30 May, 2022

Mr Thomas Piovesan
Department of Planning & Environment,
Thomas.piovesan@dpie.nsw.gov.au

The Star MOD 18

Figure 53 CAM14: Watermark Pavilion, central section, 8th storey, comparison between original and revised proposal

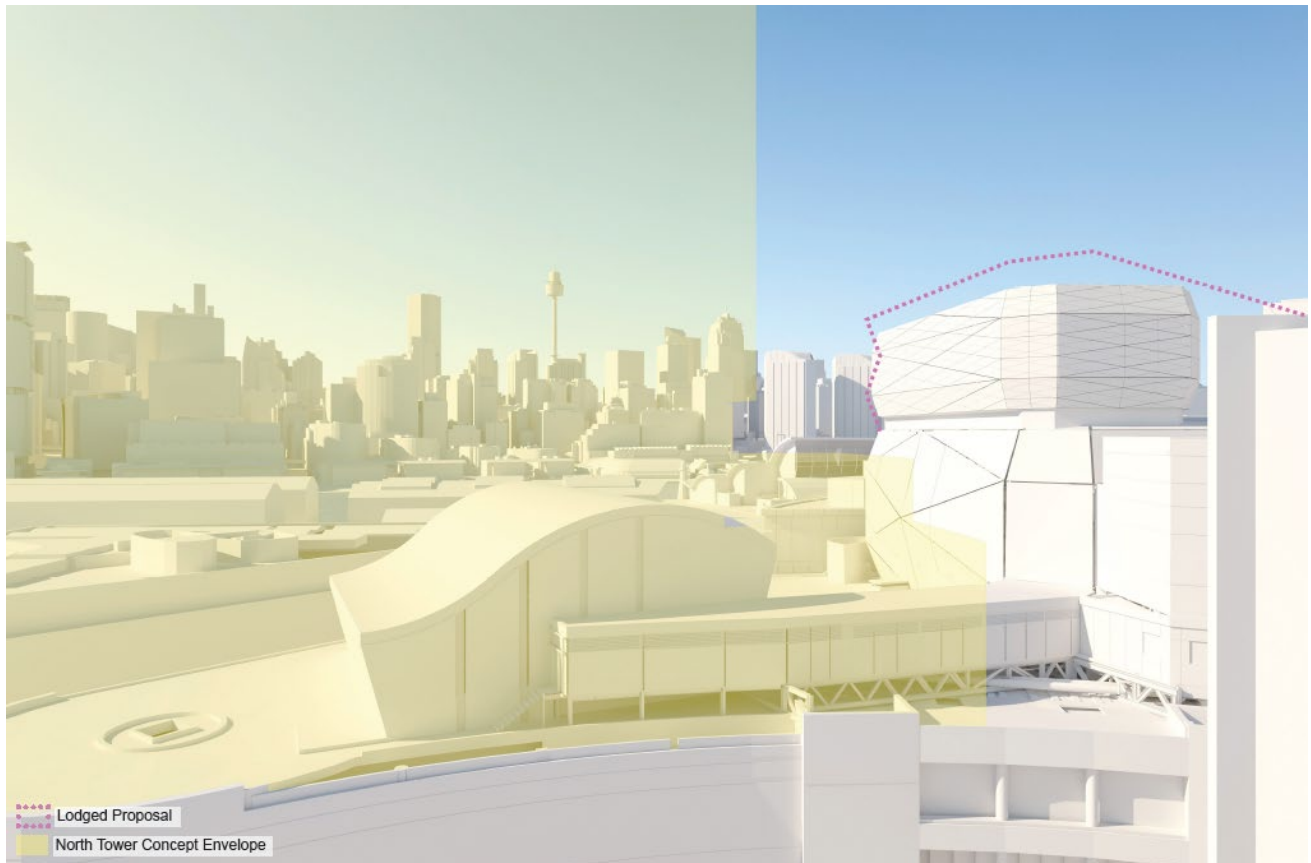
- 2.0 **Visual Impacts** – Fig 53 of the Visual Impact Assessment of the proposed developments indicates that there will be moderate to severe impacts for residents living in the Watermark apartment building, immediately opposite the

- area to be used for the expansion of the fly-tower, rigging loft, dressing room complex and plant tower. Residents living in apartments on the 5th, 6th, 7th 8th and 9th floors will have significant loss of open sky views. **Every effort should be made to minimize the scale of the proposed rooftop structures.**
